**ENVIRONMENTAL ASSESSMENT
TO ACCOMPANY A SECTION 75W
APPLICATION FOR
Proposed Modifications to MP 07_0093
At
Lot 5, Interlink Industrial Estate
Mamre Road
Erskine Park**

ADDENDUM

**Prepared for
Goodman Limited**

Job No. 11150A
EA-Addendum Final.doc
February 2012

INT DA601 (G)

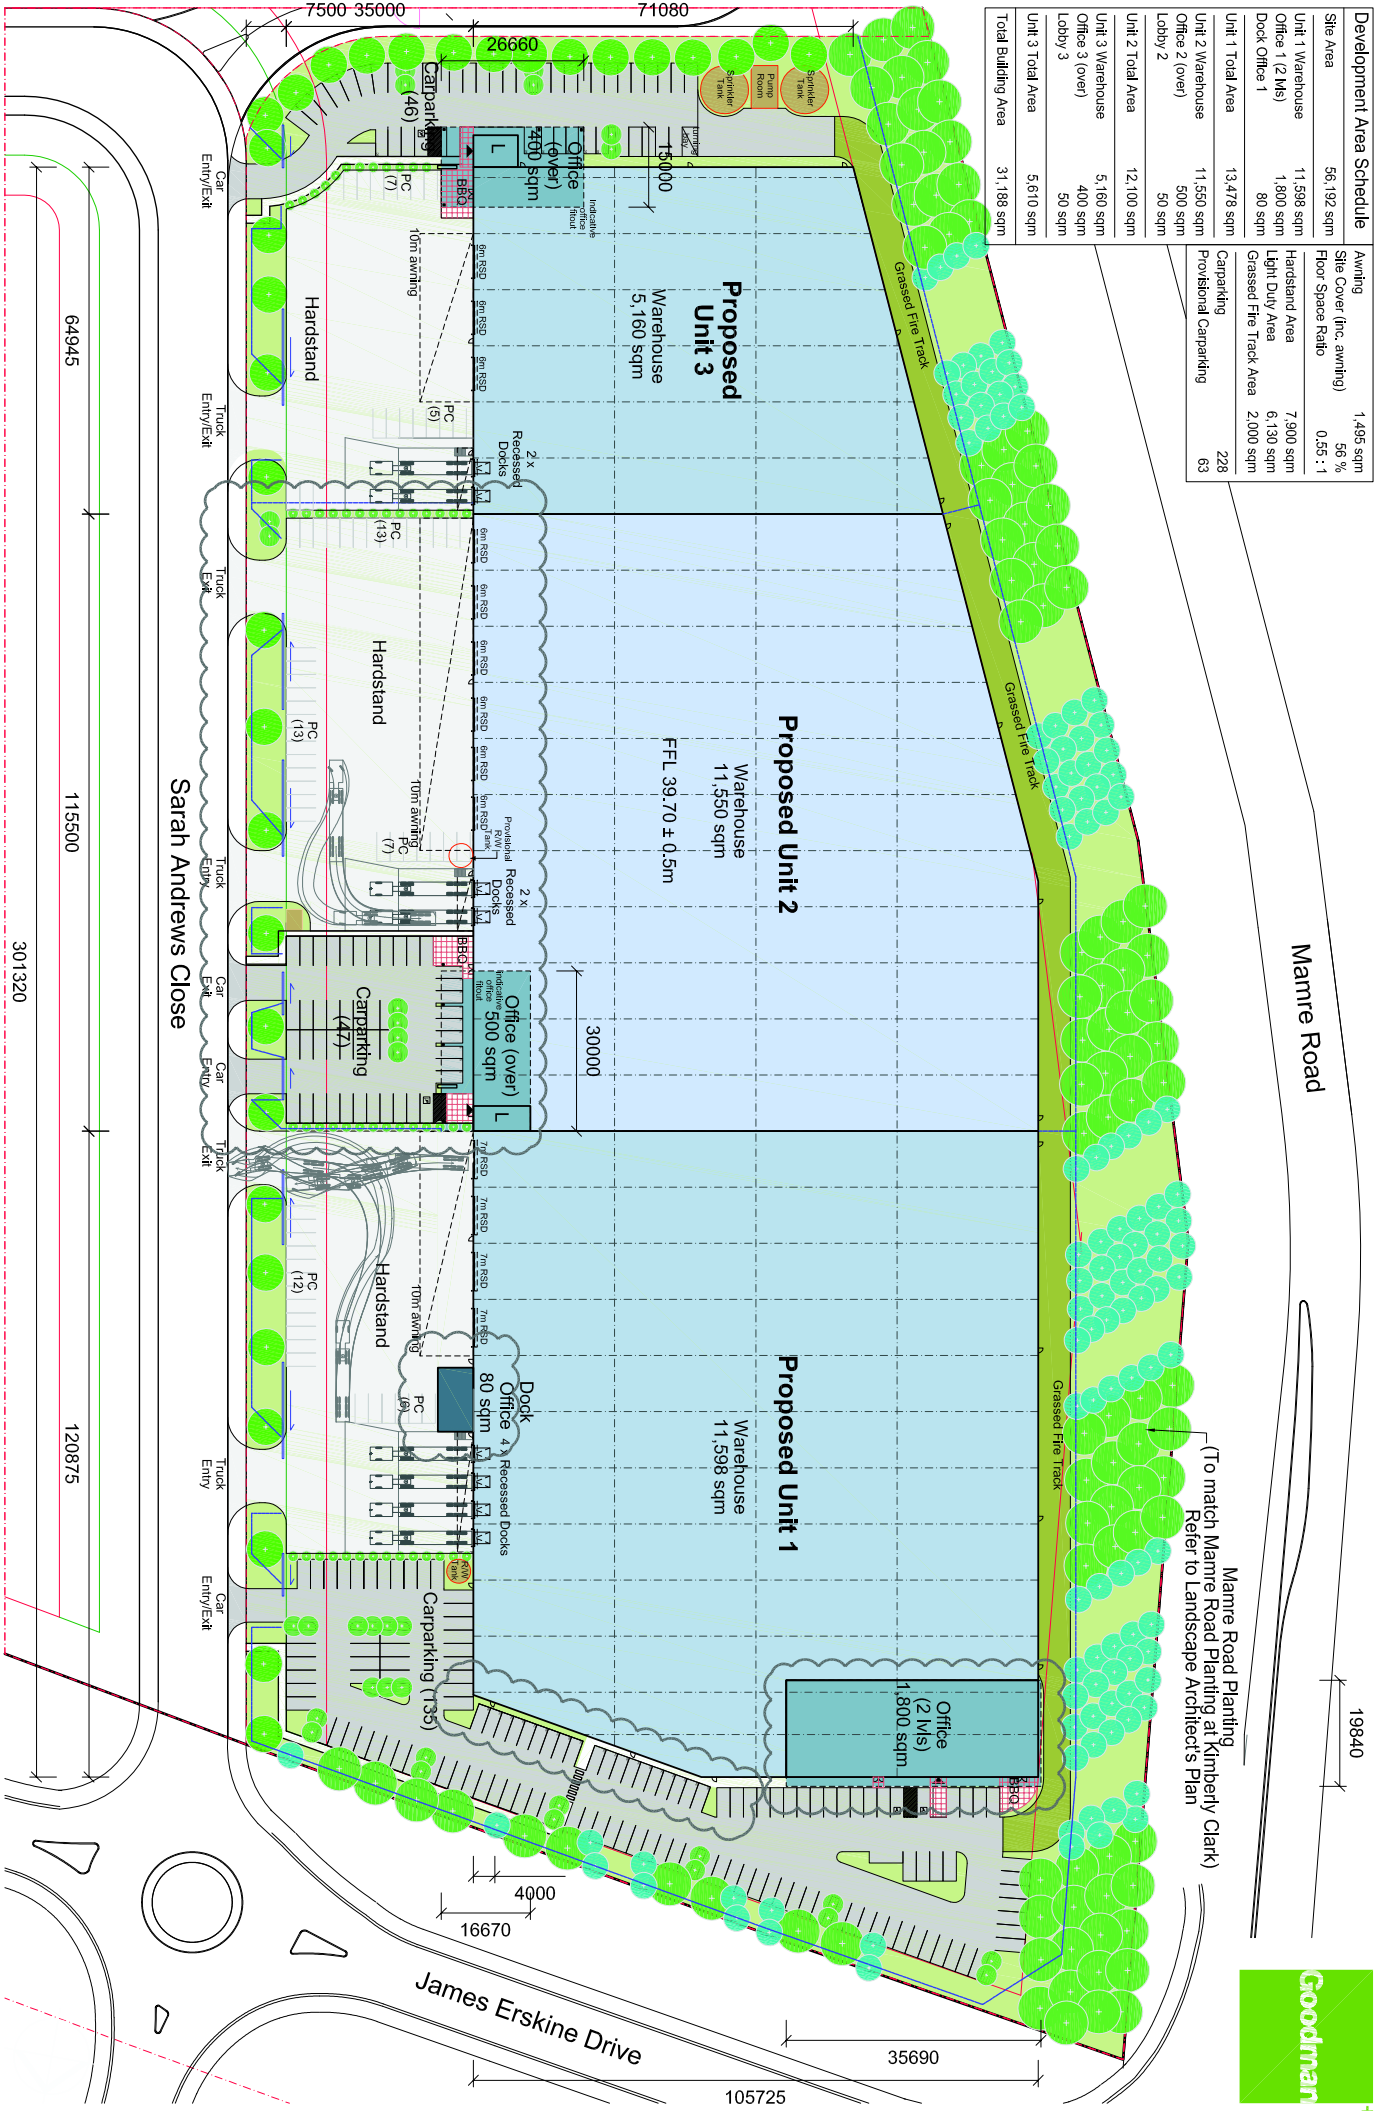
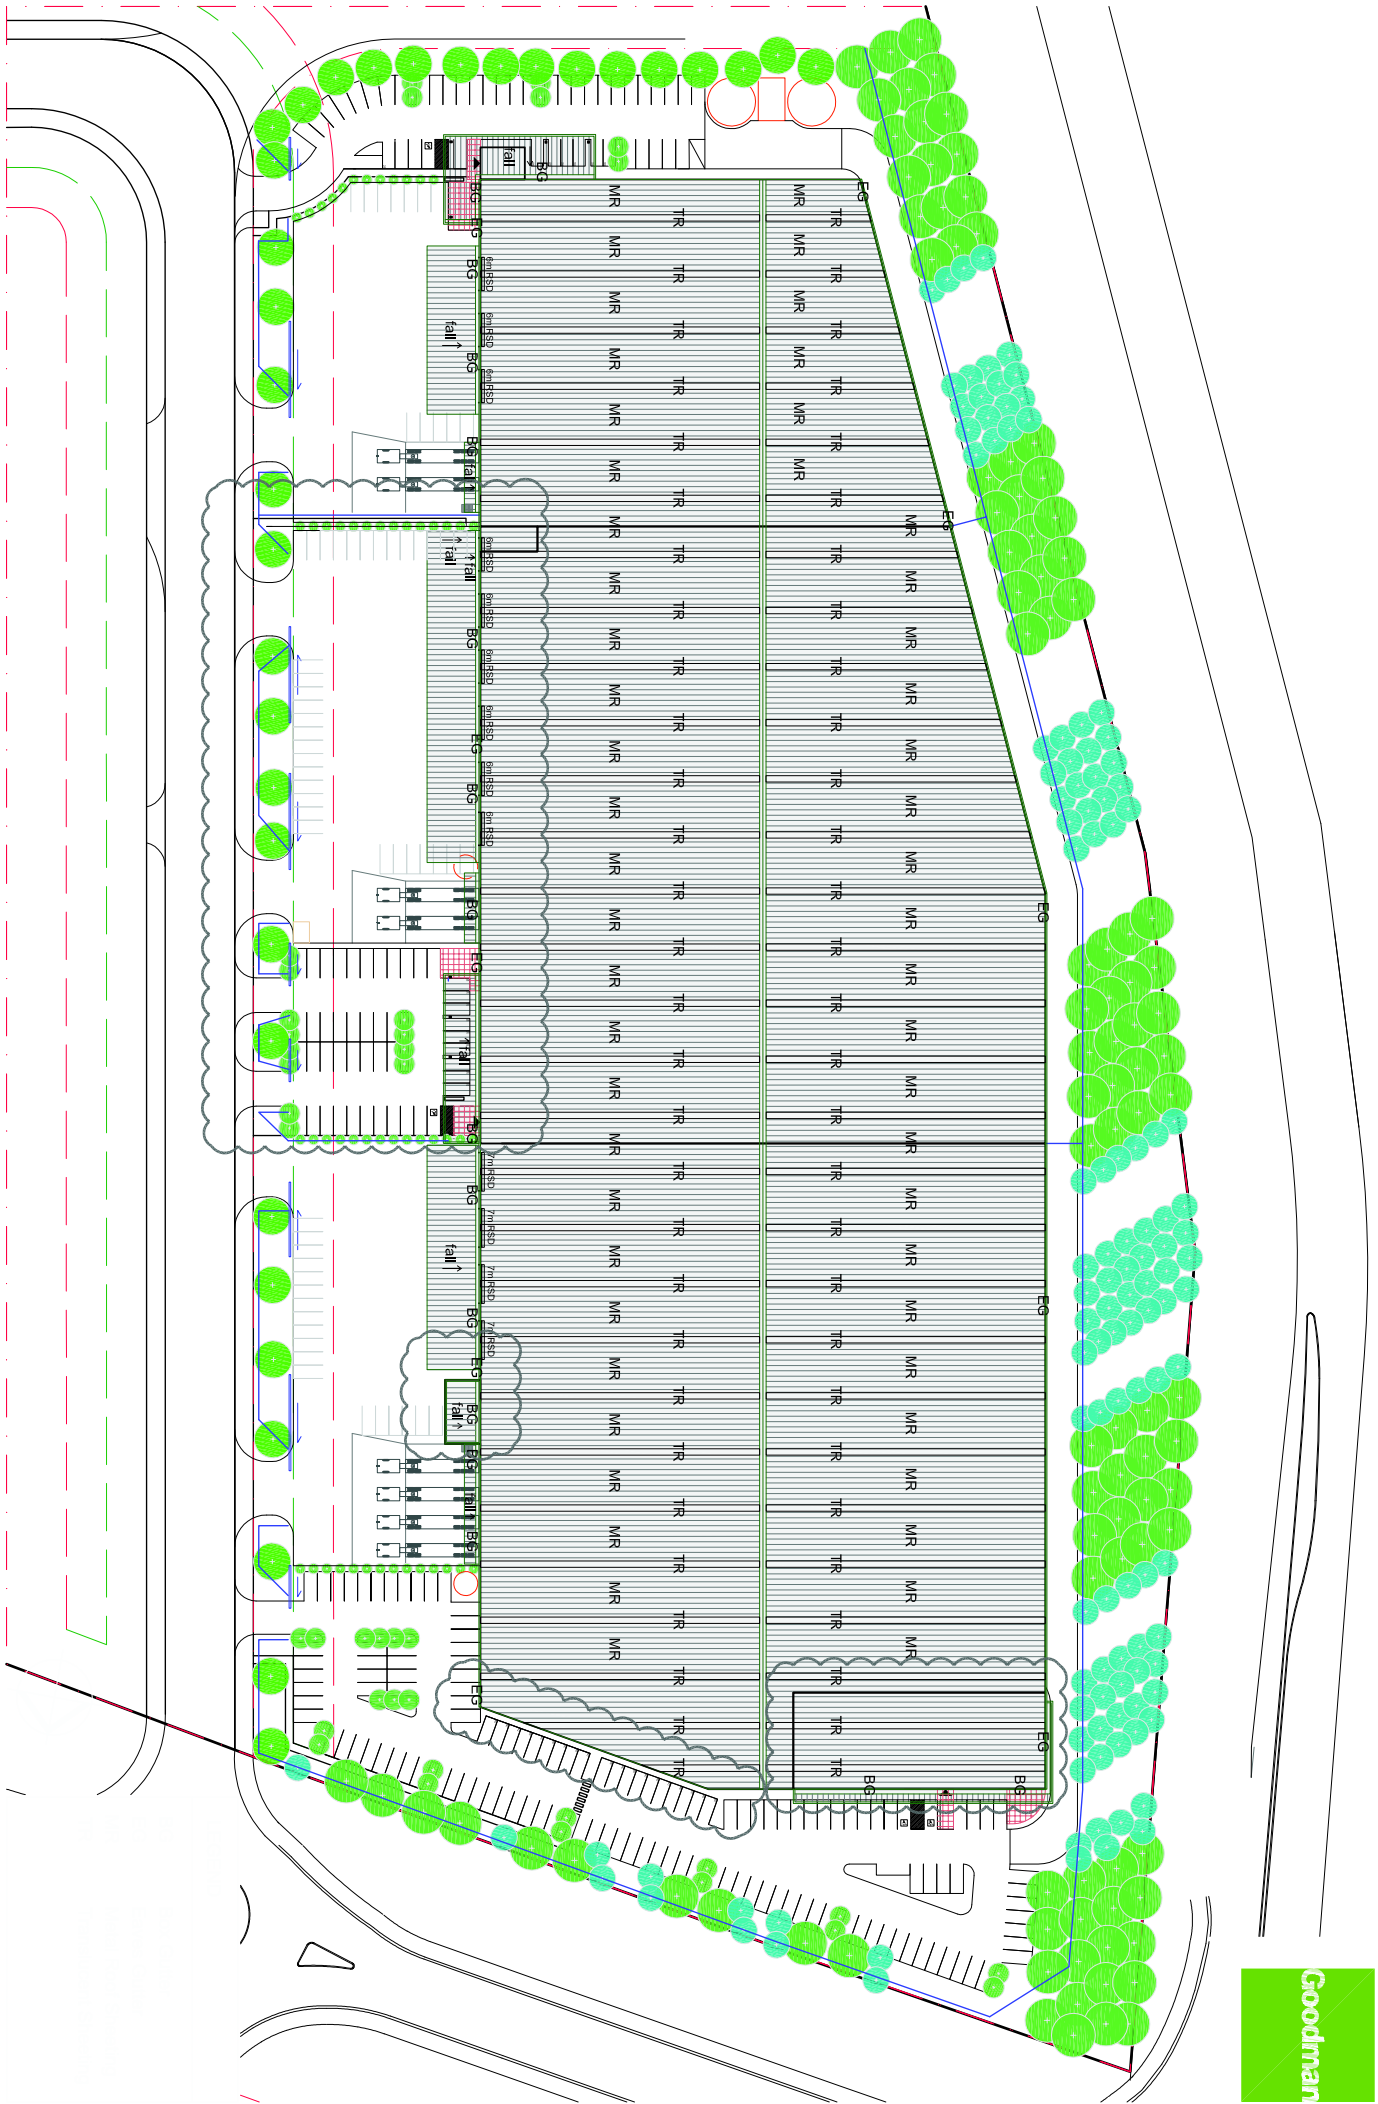
Unit 1

- Warehouse Gross Floor Area (GFA) decreases from 12,035m² to 11,598m²;
- Office GFA increased from 1,167m² to 1,800m²;
- Dock Office shifted north to be in between flush and recessed docks;
- Dock Office area increases from 60m² to 80m²;
- Car parking numbers increase by 20 spaces, from 115 to 135 spaces; and
- Provisional car parking increases from 5 spaces to 18 spaces.

Unit 2

- Office and associated car parking shifted towards northern end of the loading area;
- Flush and recessed loading docks shifted towards the southern end of the loading area; and
- Provisional car parking increases from 20 spaces to 33 spaces.
